**IMAX Redevelopment (MOD 8) (SSD-7388-Mod-8)  
Request for Additional Information**

I refer to the above application for the IMAX Redevelopment (SSD-7388-Mod-8).

Mod 6 Ground Floor

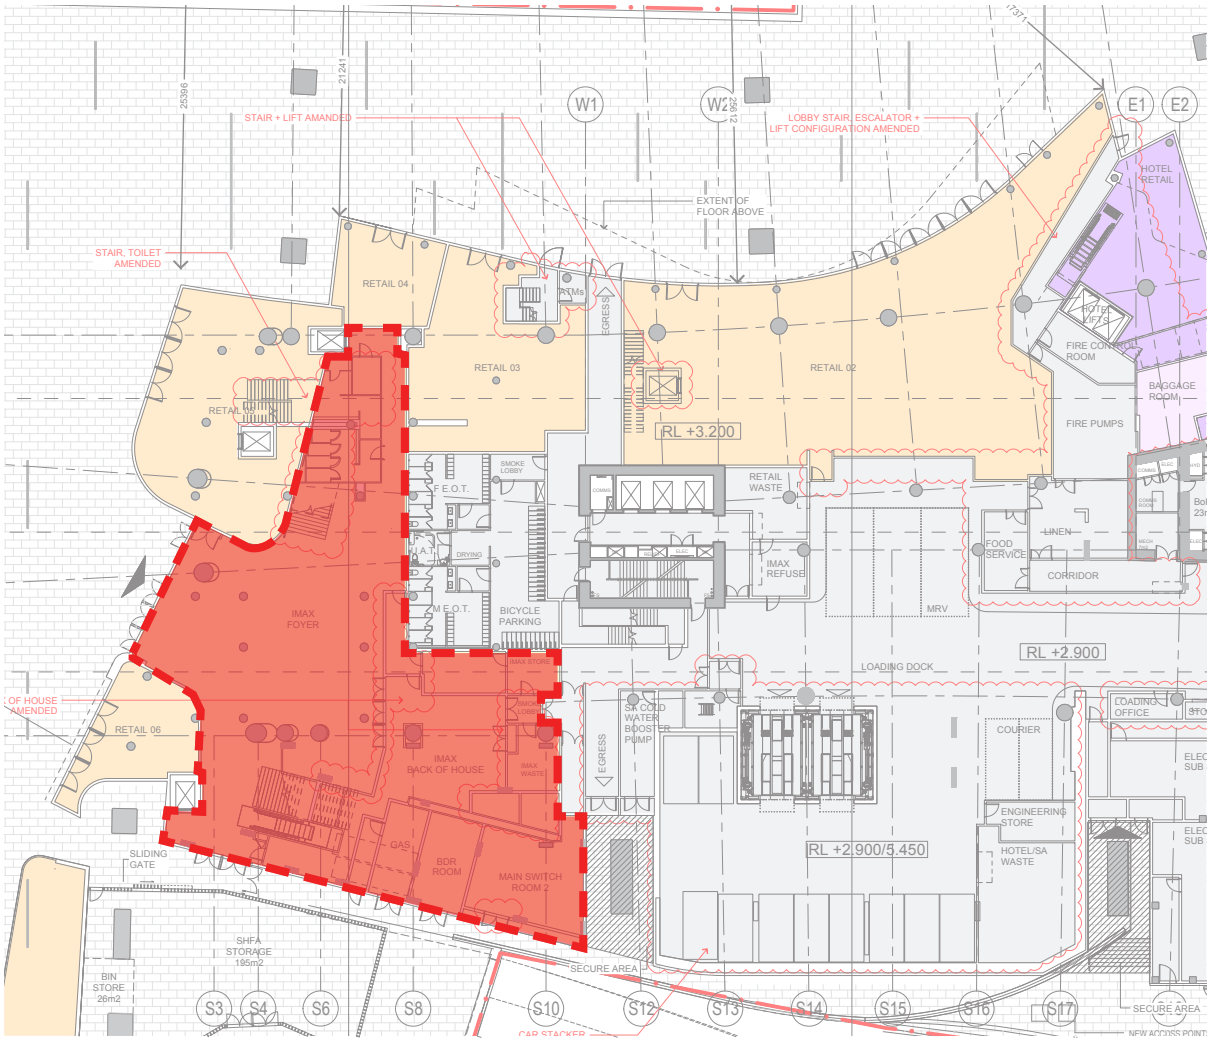
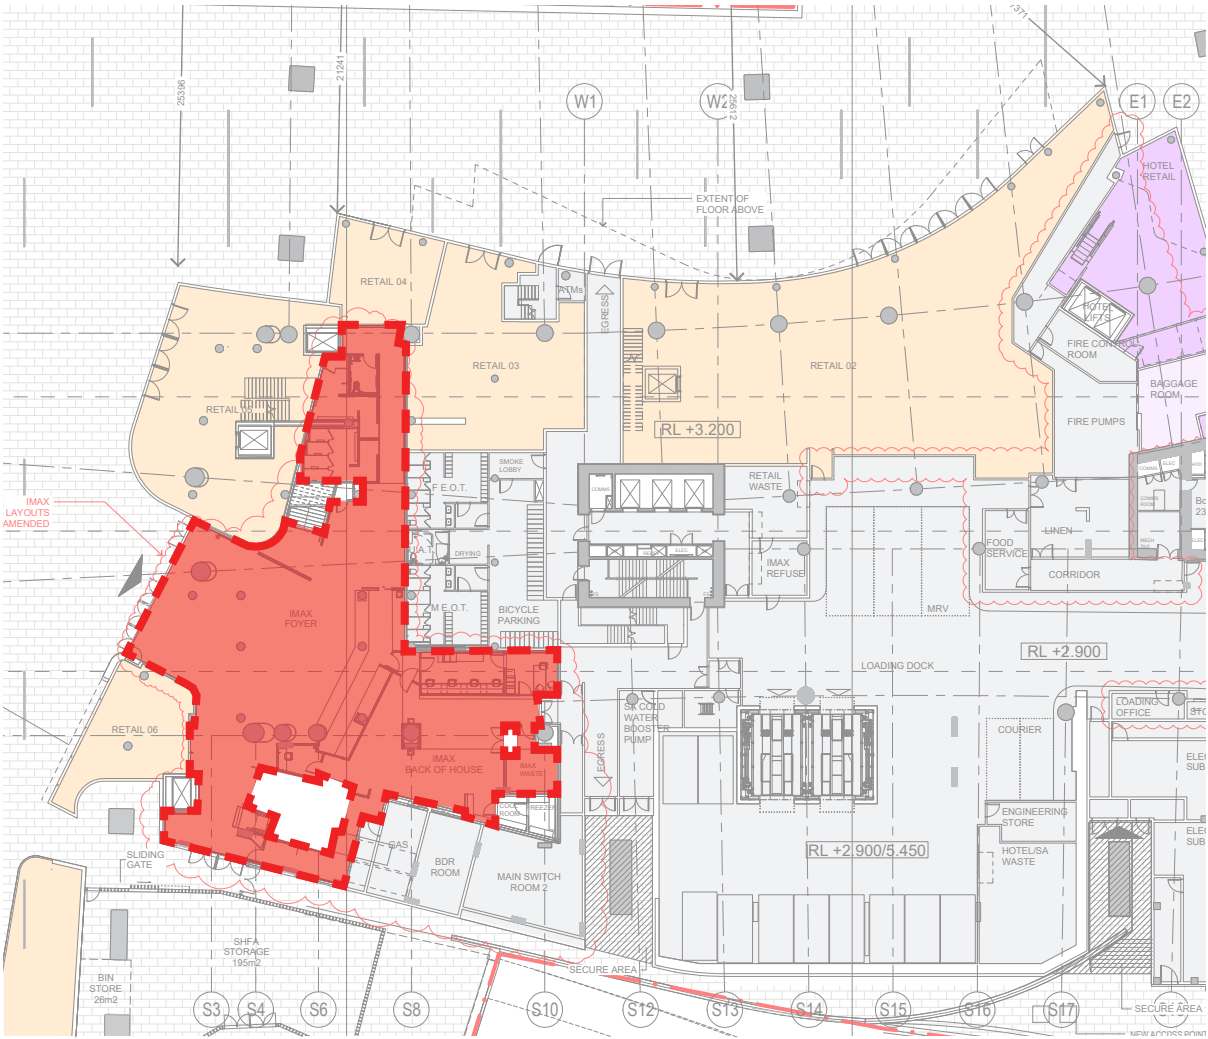
The changes to the approved IMAX cinema GFA identified in the schedule on drawing no. ARC-HSL-DD-1052 REV S do not appear to reflect the changes shown on plan. Furthermore, the submitted plans do not appear to correspond with all changes identified in the Modification Report, specifically with respect to the proposed relocation of the projection room from level 4 to level 5.
